REDTAIL RANCH FILING NO. 1

A REPLAT OF LOTS 1 AND 2, WALKER PLACE, TOGETHER WITH A PORTION OF SECTION 9, TOWNSHIP 12 SOUTH, RANGE 65 WEST OF THE SIXTH PRINCIPAL MERIDIAN, EL PASO COUNTY, COLORADO

REDTAIL RANCH FILING NO. 1
2525.00
MARCH 13, 2018
REV. NOVEMBER 15, 2018
SHEET 2 OF 3

A REPLAT OF LOTS 1 AND 2, WALKER PLACE, TOGETHER WITH A PORTION OF SECTION 9, TOWNSHIP 12 SOUTH, RANGE 65 WEST OF THE SIXTH PRINCIPAL MERIDIAN, EL PASO COUNTY, COLORADO

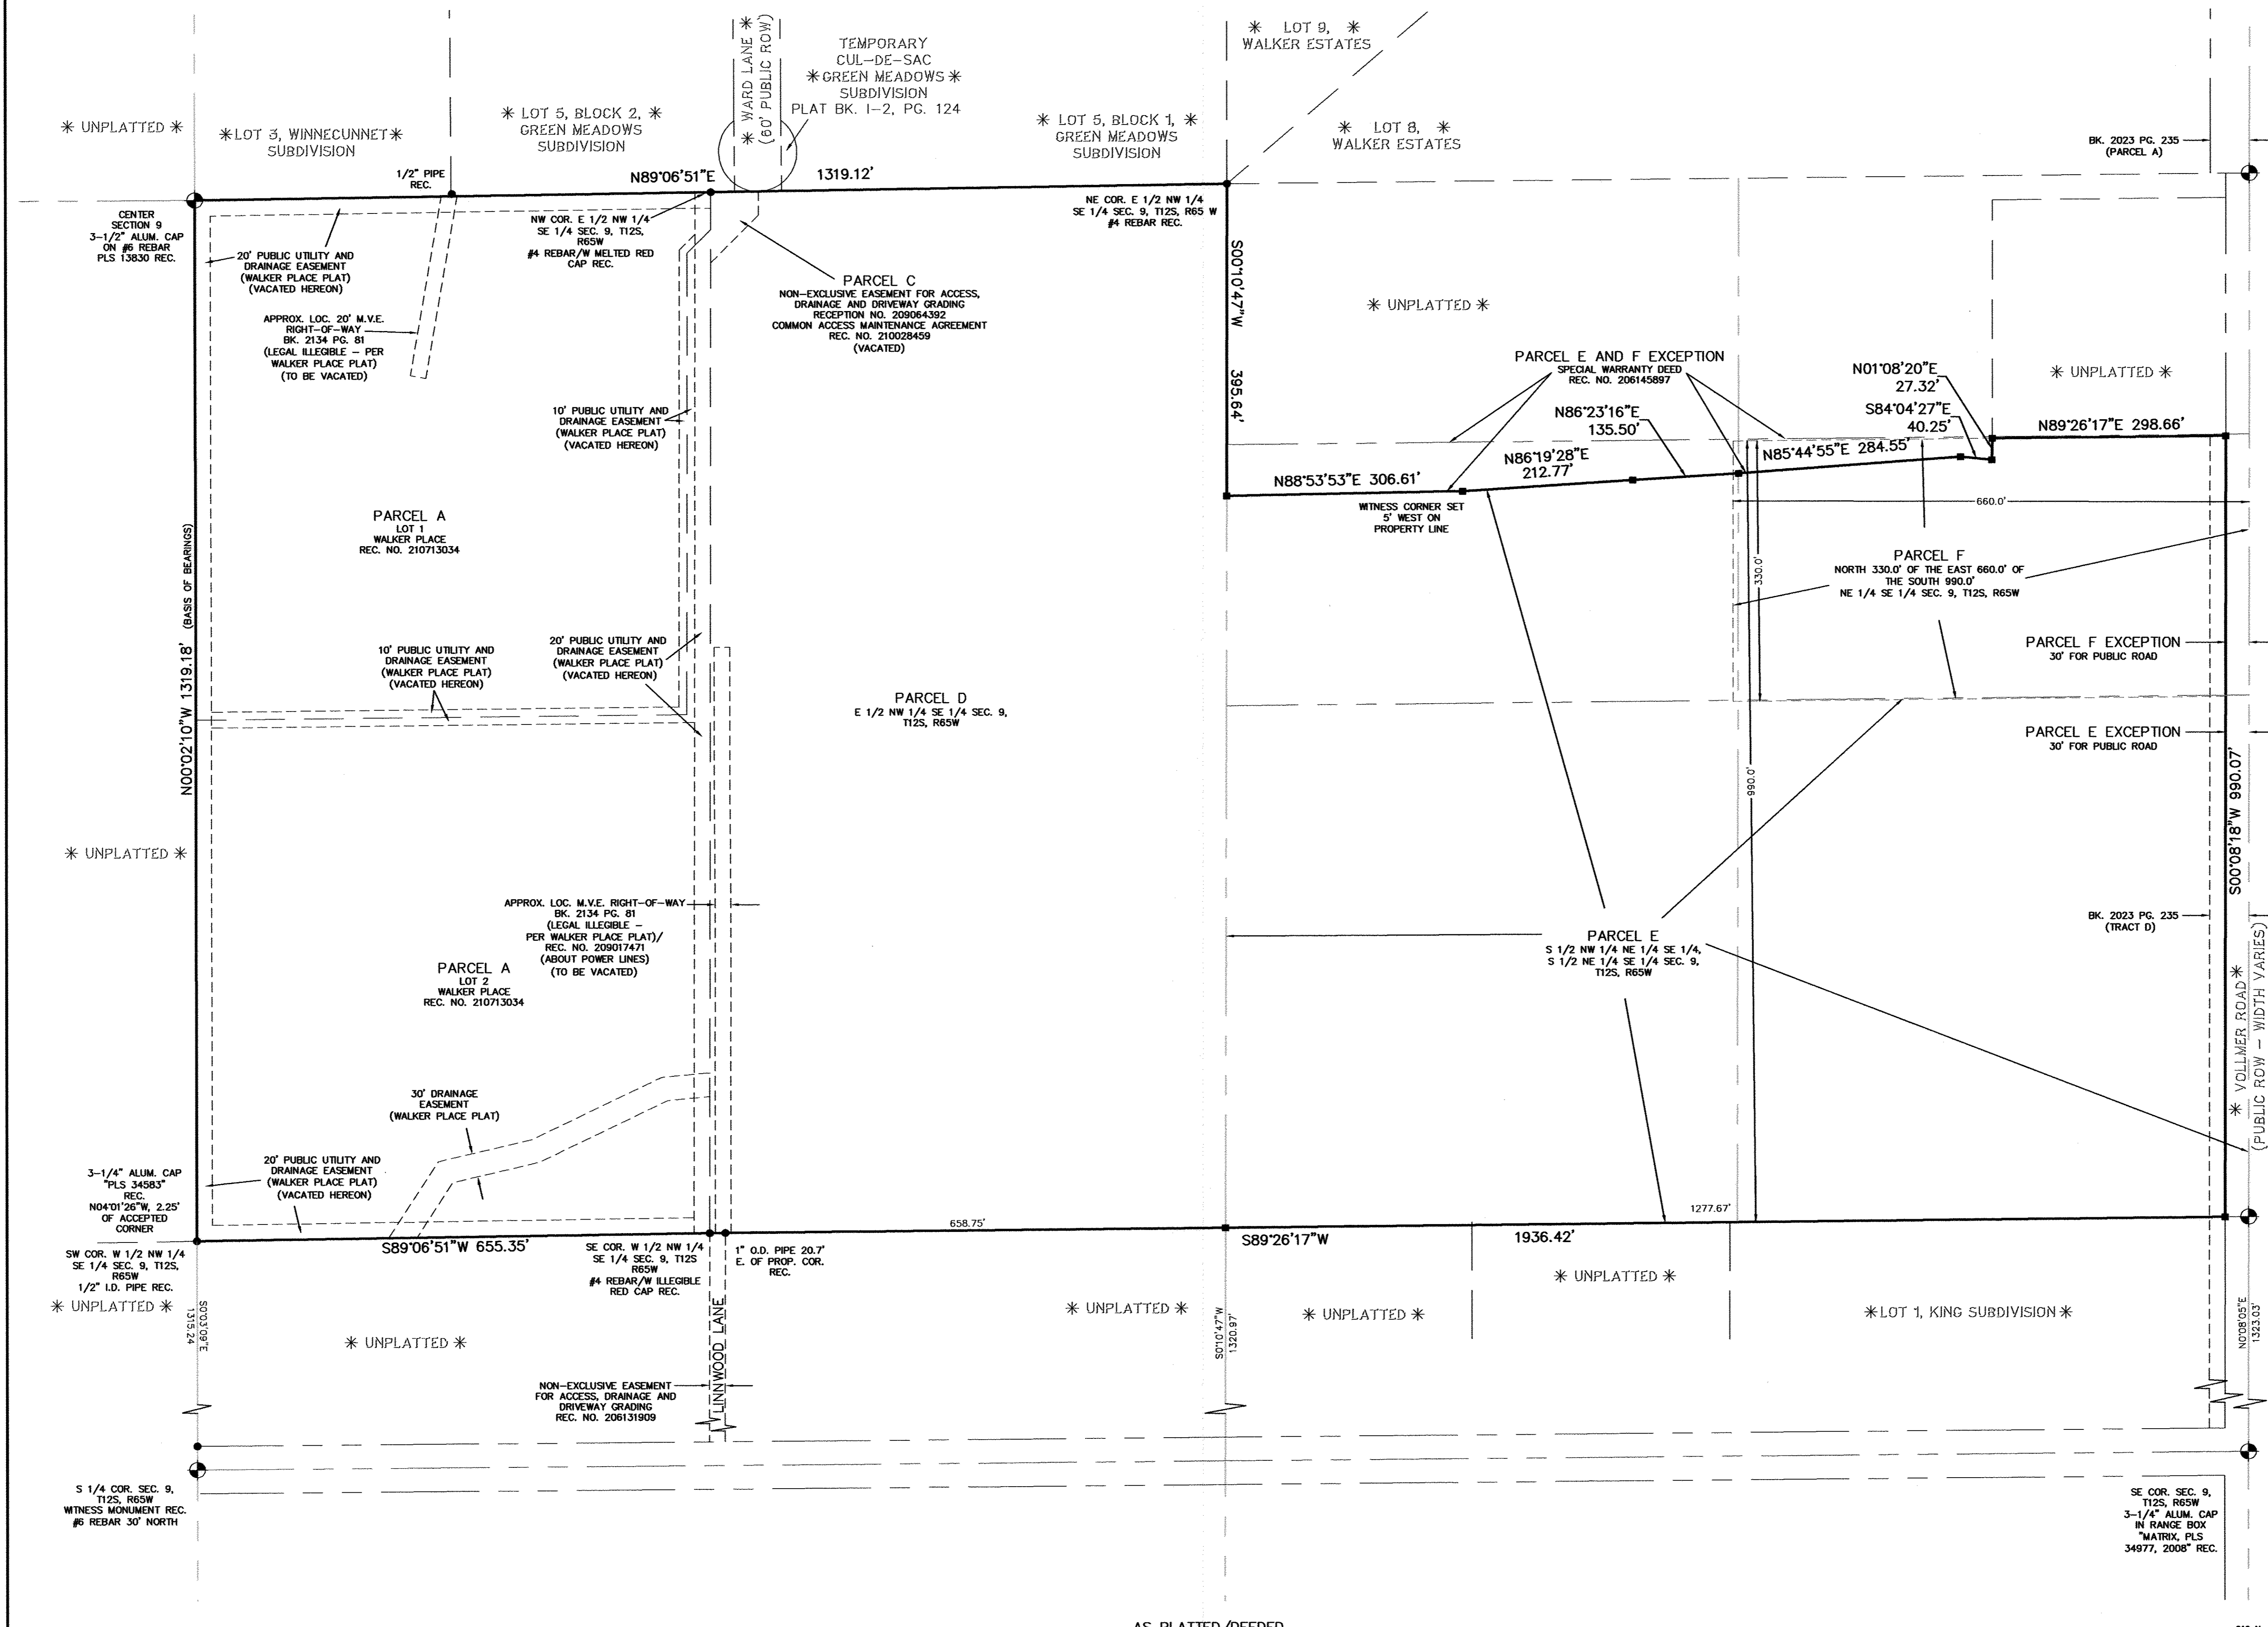
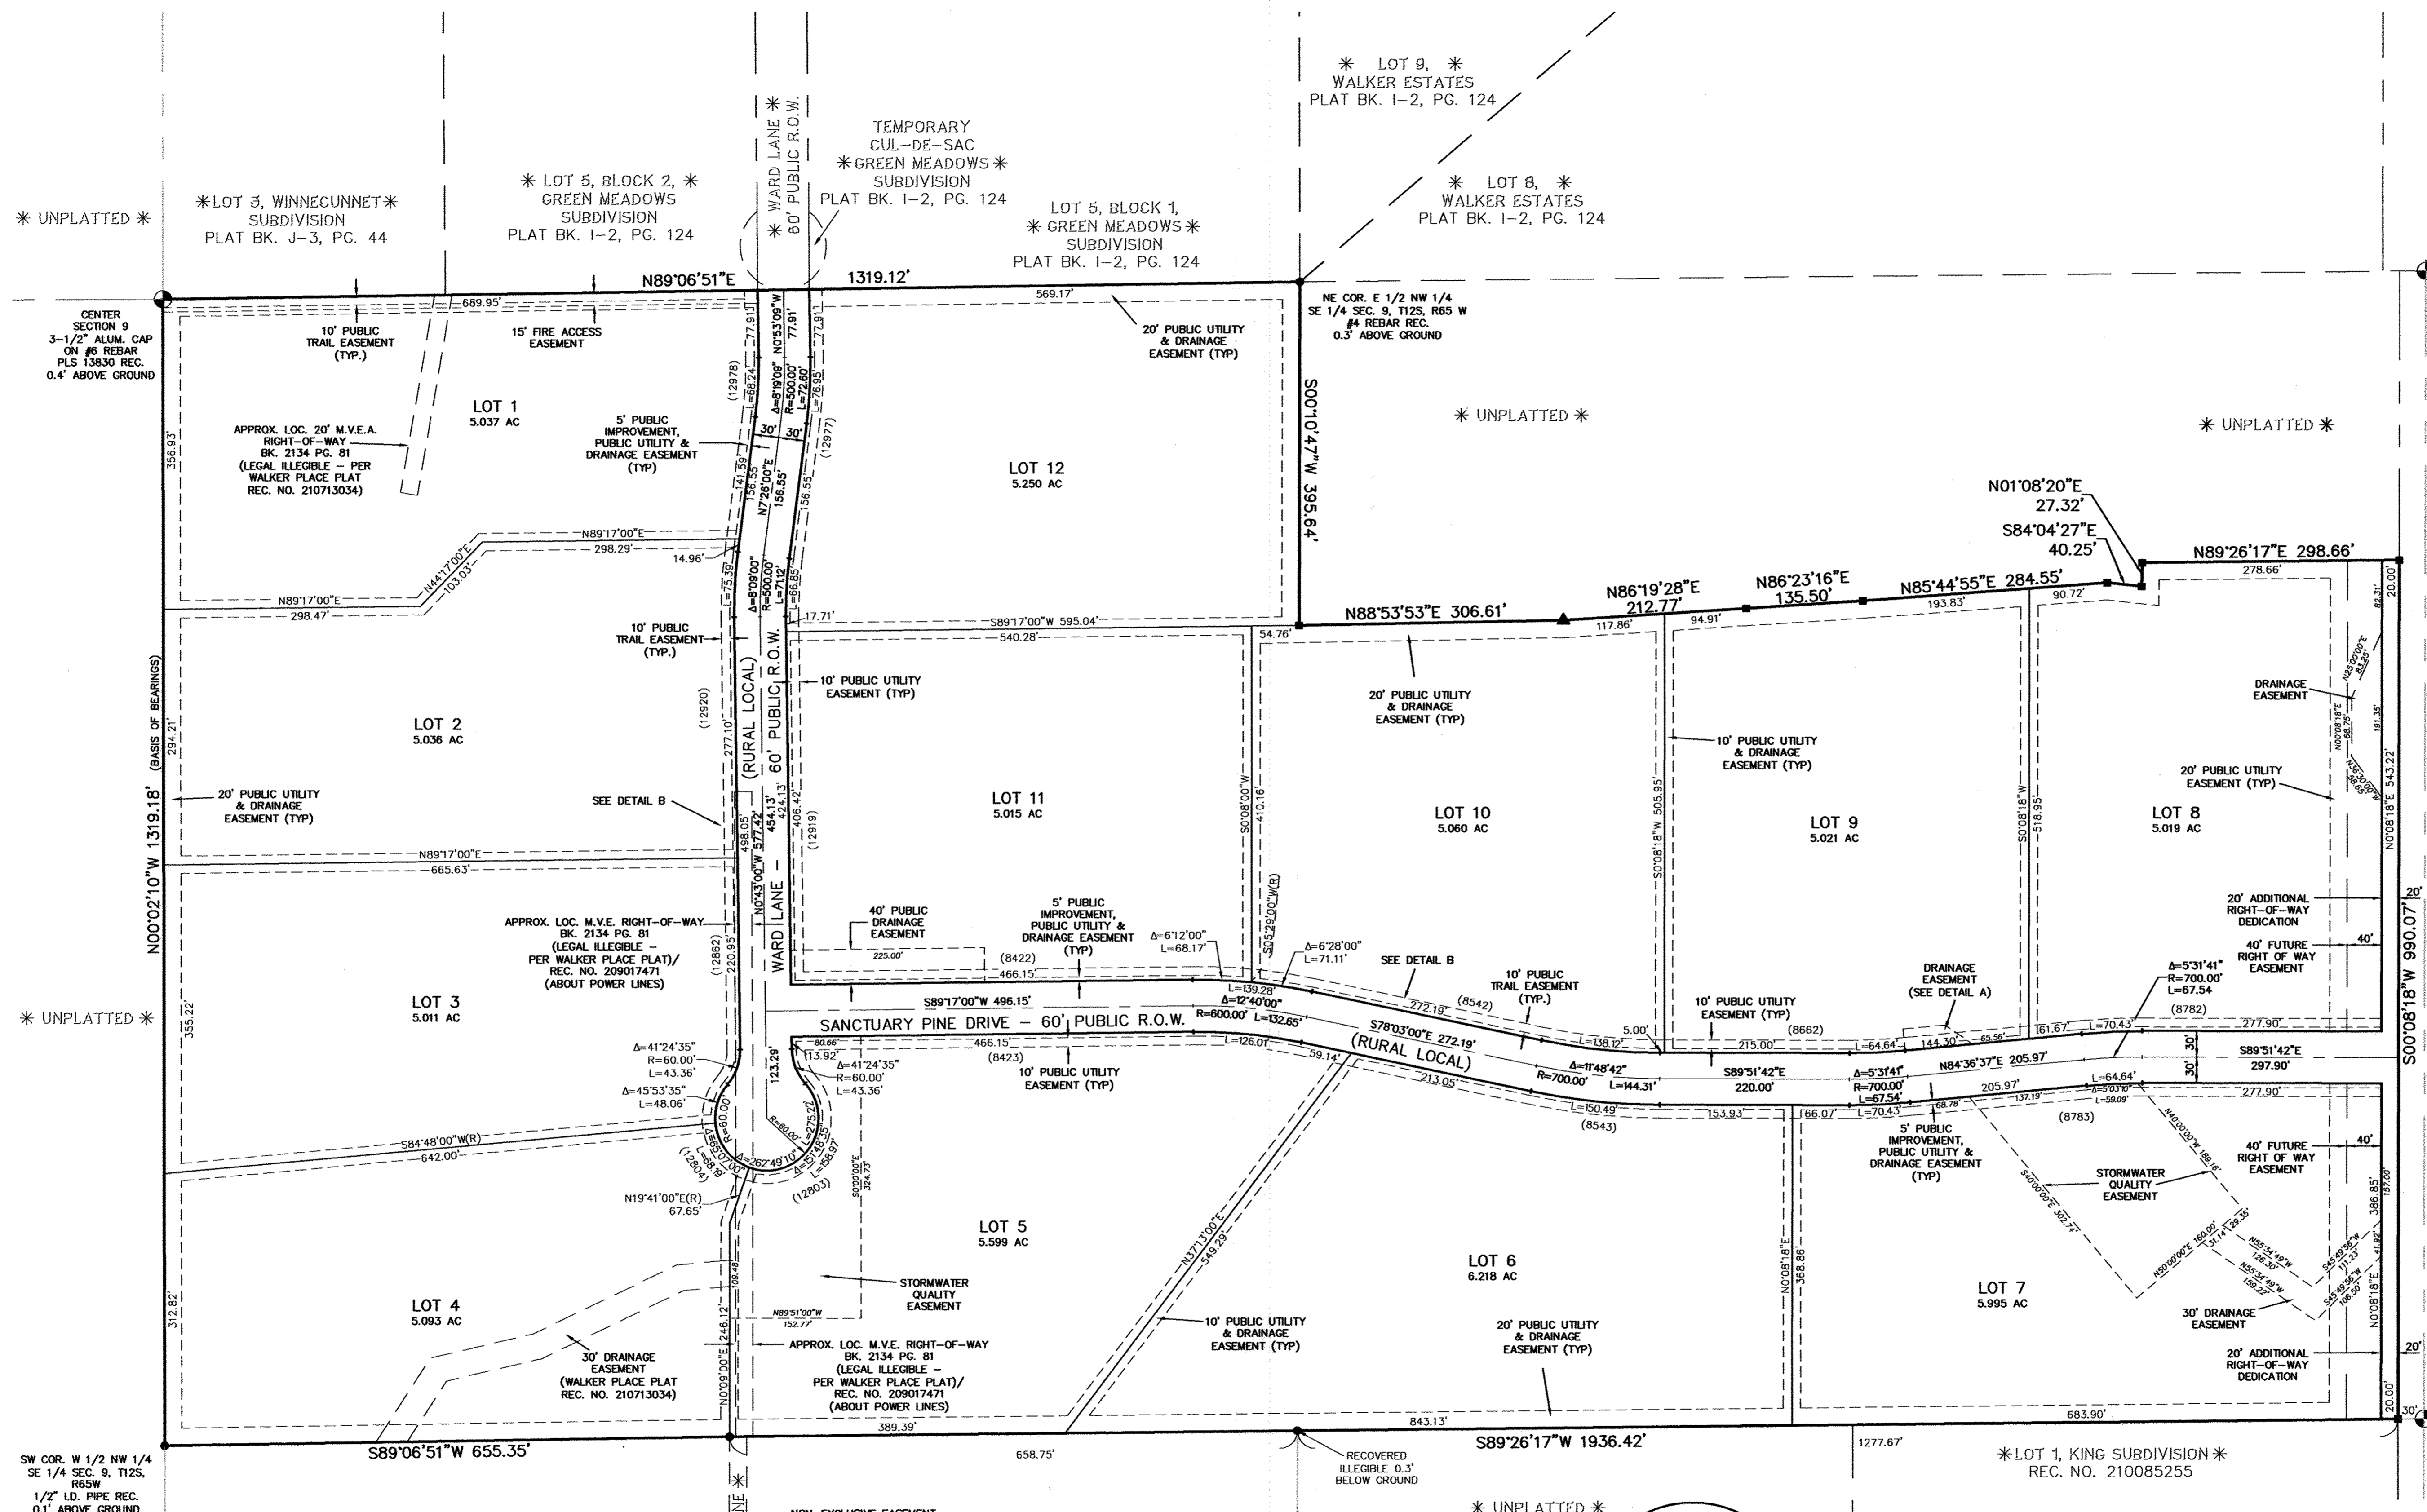
Show and label cross-lot drainage easements per PDR/FDR.

I thought the trail was outside of the cross section? Is BFTA going to be responsible for utility easements also?

Trail easement should be outside of the 5' PIE which includes the ditch.

Should there be an additional easement for utilities so when the public utility row is expanded there is a place for easements to go?

These lot areas need to reflect the lot size after ROW dedication. You may leave the easement in the lot size calculation but dedicated ROW must be removed. See preliminary comments.

Detail B (Trail easement and utility easement overlap)
